# London Luton Airport Expansion

Planning Inspectorate Scheme Ref: TR020001

**8.127 Applicant's Response to Deadline 5 Submissions**

**Appendix D - Dacorum Borough Council, Hertfordshire  
County Council and North Hertfordshire Council**

Figure 15 Site 128 Classified Counts – Vehicle Split

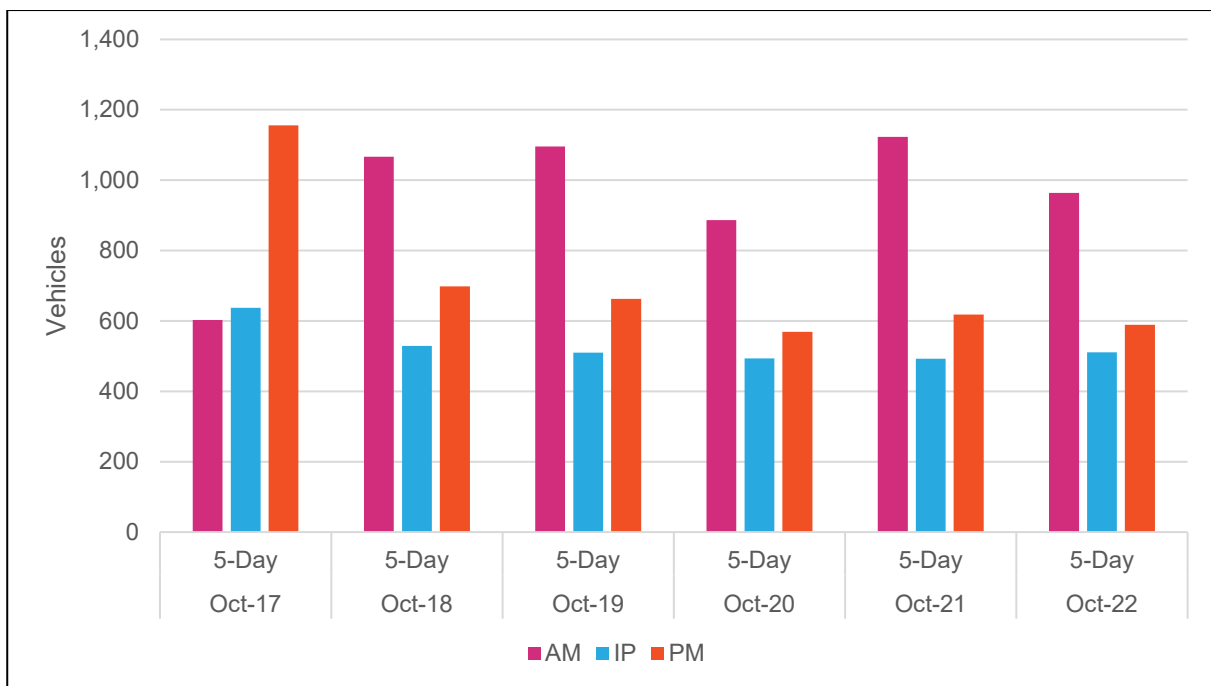
21	Surface Access	<p>Figure 15 – covid 19 modelling</p> <p>The Applicant should confirm what time period is represented in Figure 15. The Applicant should provide changes in traffic flow volumes (and not percentages) in AM, IP and PM Cars, HGV's and LGV's where the data exists as this will shows the changes in different vehicle type volumes.</p>	<p>The data presented in Figure 15 represents the vehicle split based on 12-hour traffic, 07:00-19:00.</p> <p>The Applicant considers the information is sufficient for the purpose of analysing the trends.</p>
22	Surface Access	<p>Figure 16 - Covid-19 Modelling</p> <p>The Applicant should confirm what time period is represented in Figure 16. The Applicant should provide changes in traffic flow volumes (and not percentages) in AM, IP and PM Cars, HGV's and LGV's where the data exists as this will shows the changes in different vehicle type volumes.</p>	<p>The data presented in Figure 16 represent the vehicle split based on 12-hour traffic, 07:00-19:00.</p> <p>The Applicant considers the information is sufficient for the purpose of analysing the trends.</p>

Figure 18 April Site 371 2016-2023 Weekday Two-Way Peak Counts

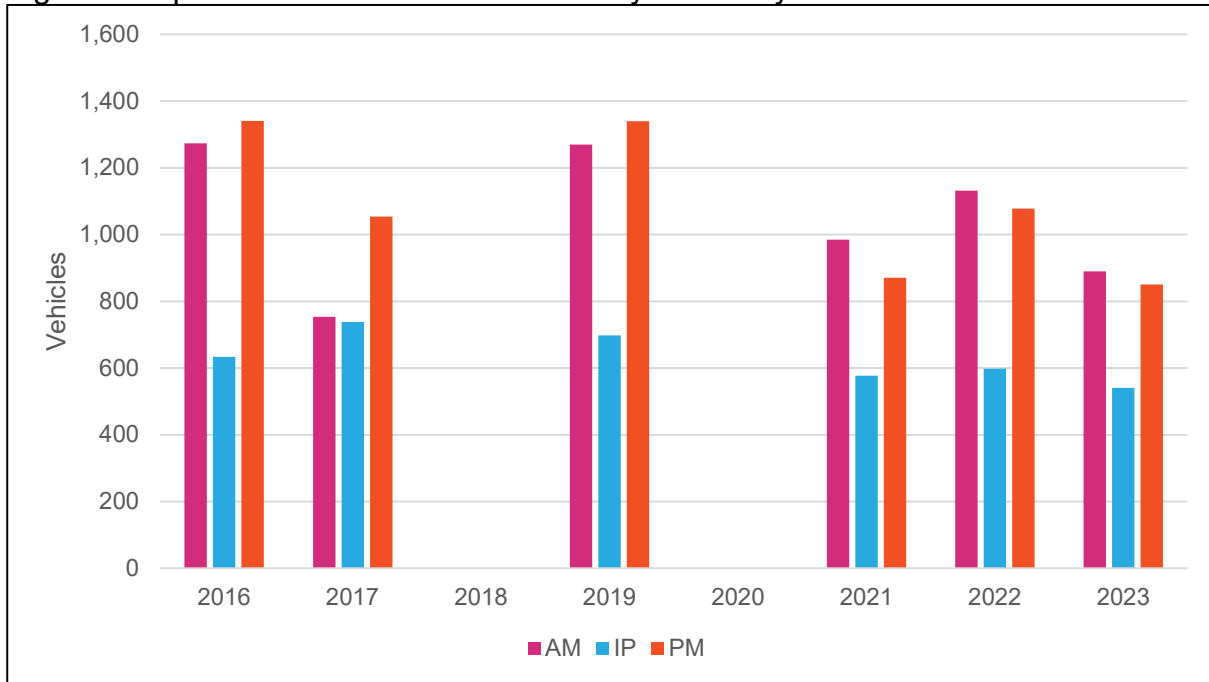
23	Surface Access	<p>Figure 18 - Covid-19 Modelling</p> <p>Site 371 sees a significant decrease in peak hour traffic post Covid-19. The Applicant should clarify whether they have investigated any other potential causes of this decrease, with the local authorities for example, to understand whether there is any other explanation for this reduction other than Covid-19.</p>	<p>The Applicant is not aware of any other explanation other than Covid-19.</p>
24	Surface Access	<p>Figure 20 and 22 - Covid-19 Modelling</p> <p>Sites 40 and 57 sees a significant decrease in peak hour traffic post Covid-19. The Applicant should clarify whether they have investigated any other potential causes of this decrease, with the local authorities for example, to understand whether there is any other explanation for this reduction other than Covid-19.</p>	<p>The Applicant is not aware of any other explanation other than Covid-19.</p>

Figure 3.3 MT1 monitoring process overview

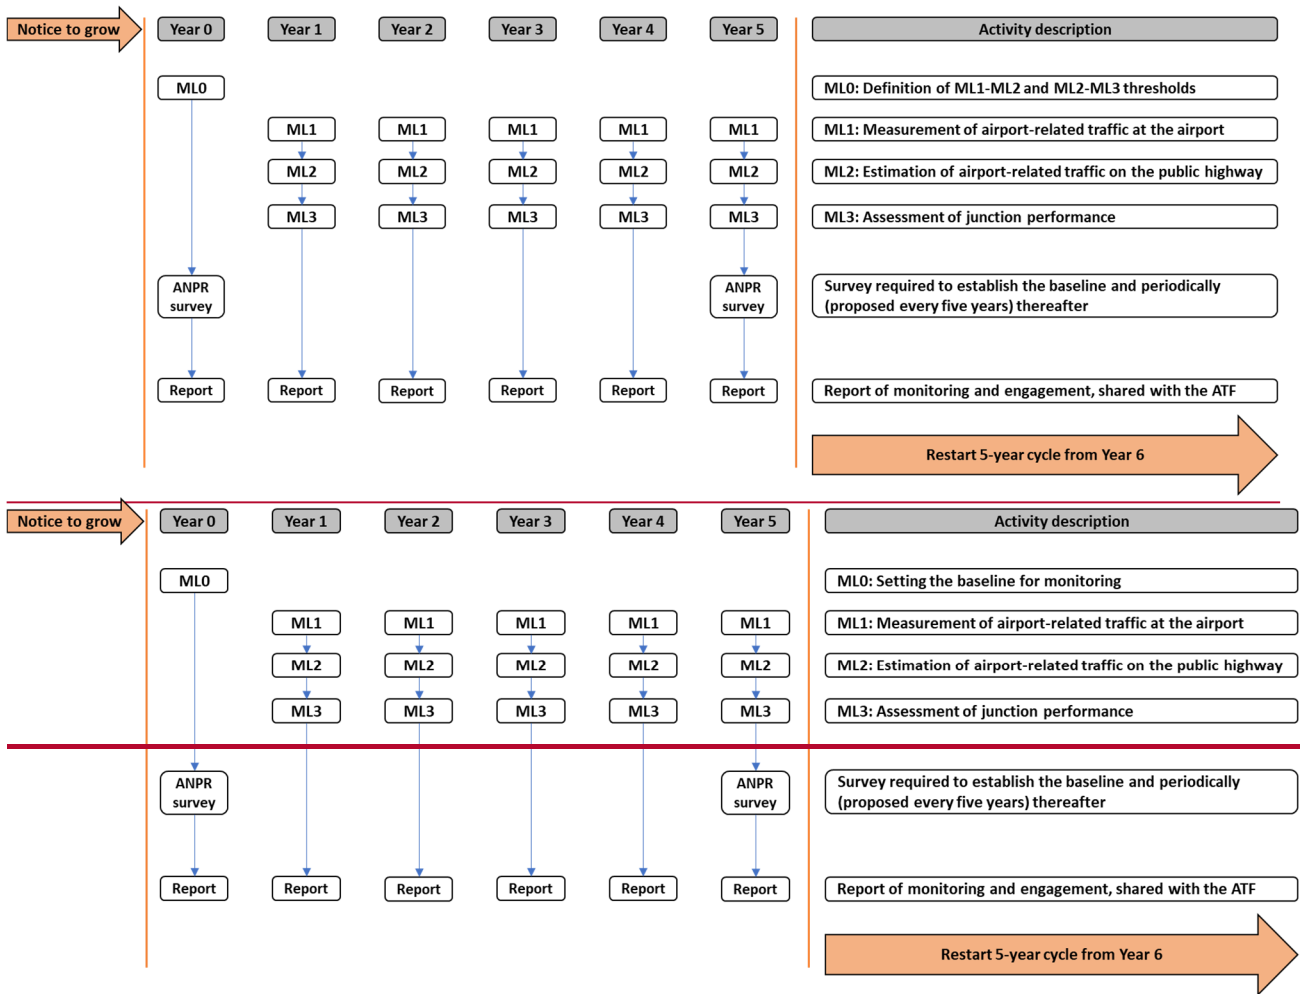
15	Surface Access	<p>Para 3.3.2 / Figure 3.3 of the Outline Transport Related Impacts Monitoring and Mitigation Approach (TRIMMA) [REP4-085]– annual MT1 monitoring is only triggered if the ML1 (monitoring in the London Luton Airport sites, e.g., car parks) exceed the ML0 (baseline of pre-growth airport trips). ML2 (monitoring at MT1 locations is triggered only when ML0 or ML1 volumes are exceeded. ML3 (monitoring of MT1 locations is only triggered if ML2 traffic levels exceed pre-defined threshold of airport traffic). This appears to propose that annual monitoring will only occur at the London Luton Airport sites such as car parks, the other MT1 sites may therefore not be monitored annually. There will be a finite amount of parking at London Luton Airport and traffic levels and patterns will also be affected by the London Luton Airport growth within the wider MT1 network. The Hertfordshire Host Authorities reject this principle and would expect to see annual monitoring across all MT1 sites to assess the airport impact.</p>	<p>MT1 sites will be monitored annually (ML2) if airport traffic exceeds any previous post-DCO maximum (ML1).</p> <p>More granular information regarding the monitoring regime will be provided in a more detailed version of the TRIMMA. Data collection will be consistent with typical collection methods (it will be of a sufficient duration and will avoid known periods of significant disruption on the transport network etc) and will enable comparison against modelled traffic.</p>
